Ribble Valley Borough Council  
Housing & Development Control

Application no: **3/2023/0302**

Address: **Land to rear of Malt Kiln House Malt Kiln Brow Chipping PR3 2GP**

Proposal: **Approval of details reserved by conditions 8b(i) (Details of internal road construction); 8b(ii) (Management and maintenance of internal roads); 17 (Surface Water from car park) of planning permission 3/2022/0568.**

PROJECT				
Proposed Residential Development at Malt Kiln Brow, Chipping.				
DRAWING TITLE				
Traffic Management Plan.				
DATE	SCALE	DRAWN	DRWG No.	REV
June 2022	1:500 @ A3	SDH	MKB/P03	E

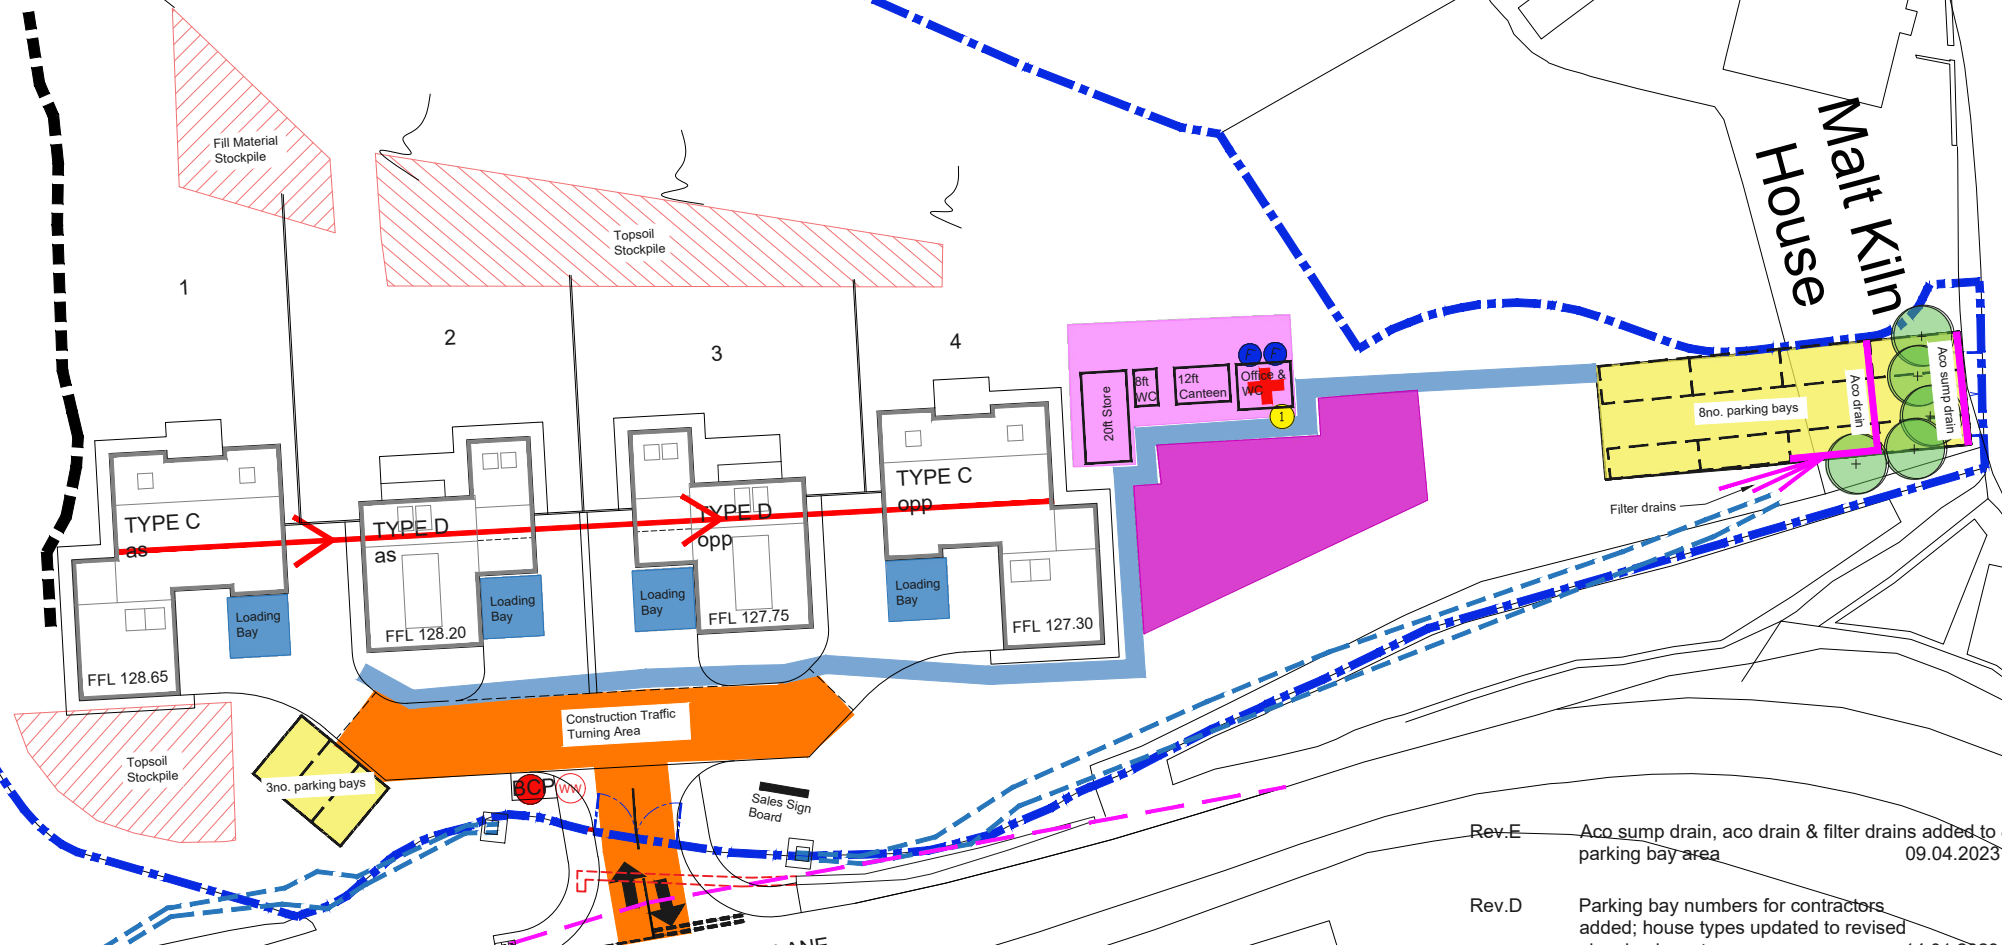
The LHA have reviewed Hodson Homes drawing number MKB/P03 Rev E titled "Traffic Management Plan" and require further information regarding where the parking area will drain to. Should the parking drain to the adjacent watercourse, the Developer is again required to gain Land Drainage Consent from the Lead Local Flood Authority. Please contact [suds@lancashire.gov.uk](mailto:suds@lancashire.gov.uk) for more information or information on the application process and relevant forms can be found at <https://www.lancashire.gov.uk/flooding/drains-and-sewers/alterations-to-a-watercourse>.
